HAYES STRUCTURAL
Consulting & Design, PLLC

Date: January 10, 2025

Re: 24-KAHD-029.2
Structural Analysis
Lot 35 Cotton Farms
318 Deer Tail Lane
Fuquay-Varina, NC 27526
Permit No.: SFD2405-0070

At your request, the structural plans were reviewed to address the attachment of the double rafter to the ridge beam above the recreation room.

**S-5**

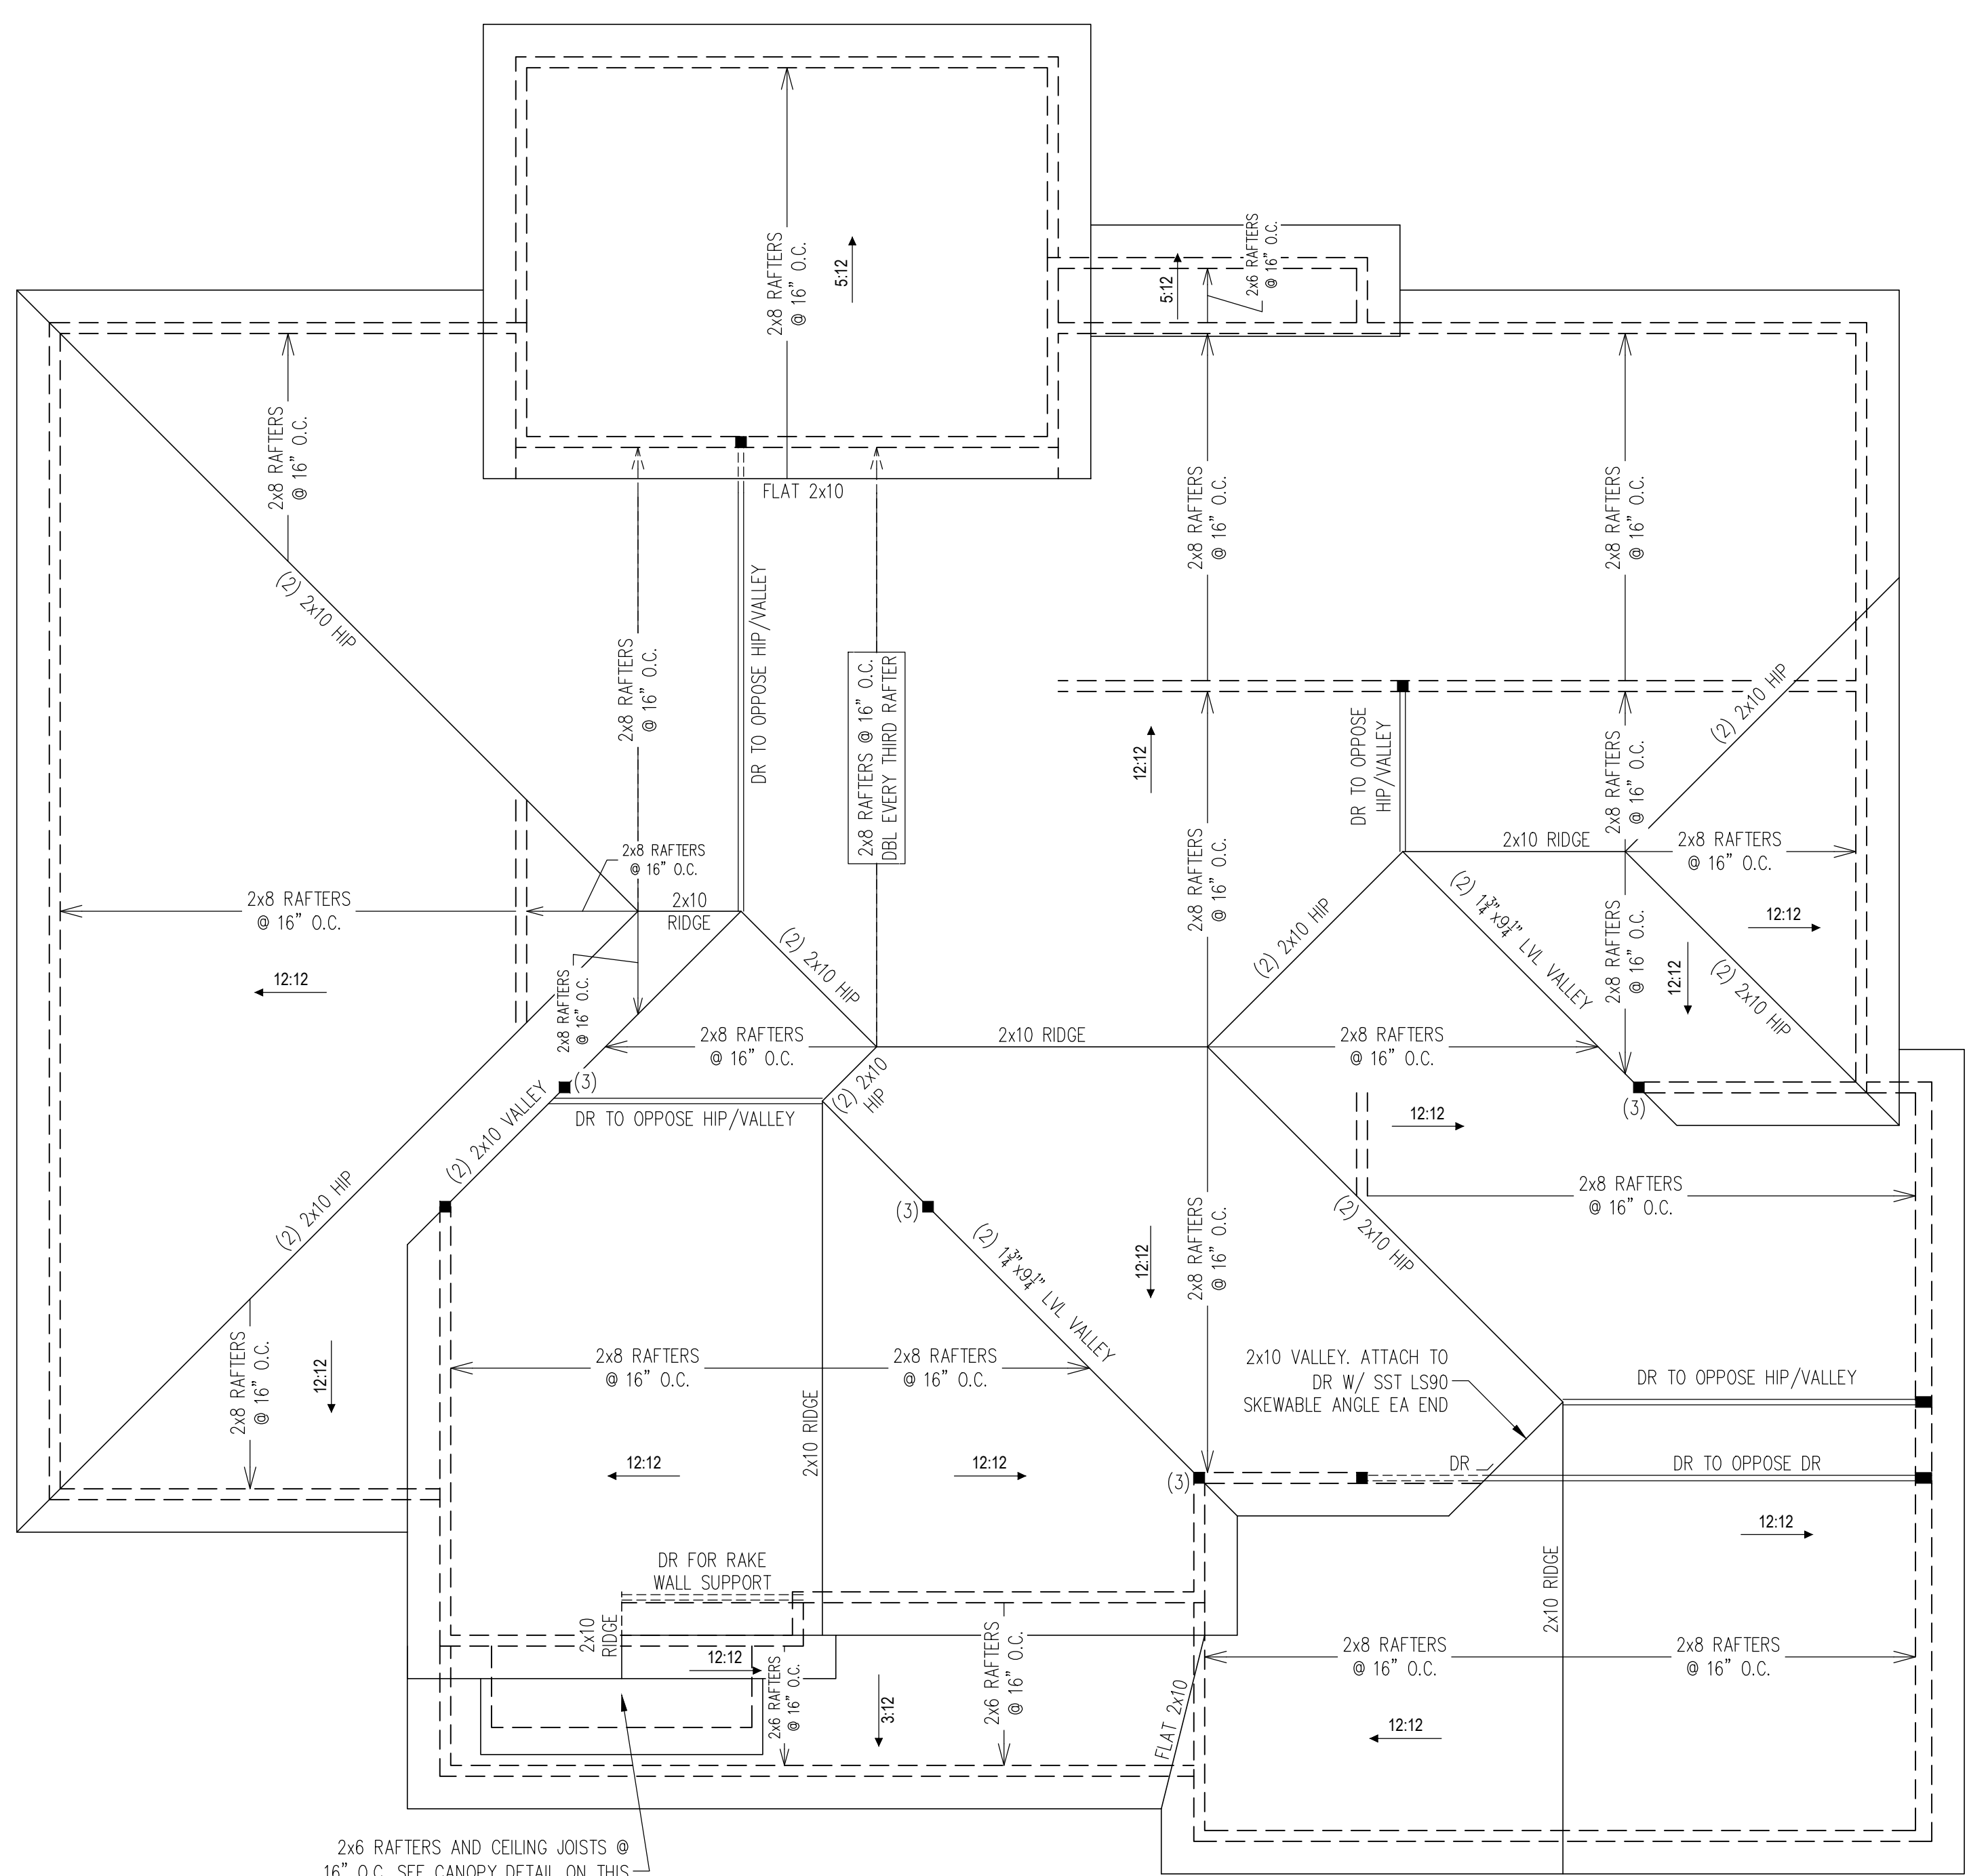
You indicated the top end double rafter is fastened to the ridge beam with a single Simpson Strong-Tie L90 angle in lieu of (2) angles per plan. You also indicated a second angle cannot be installed due to the proximity of the adjacent rafter. Analysis revealed the "as-built" single Simpson Strong-Tie L90 angle is suitable to support the loads imposed by the double rafter. A second angle is not required.
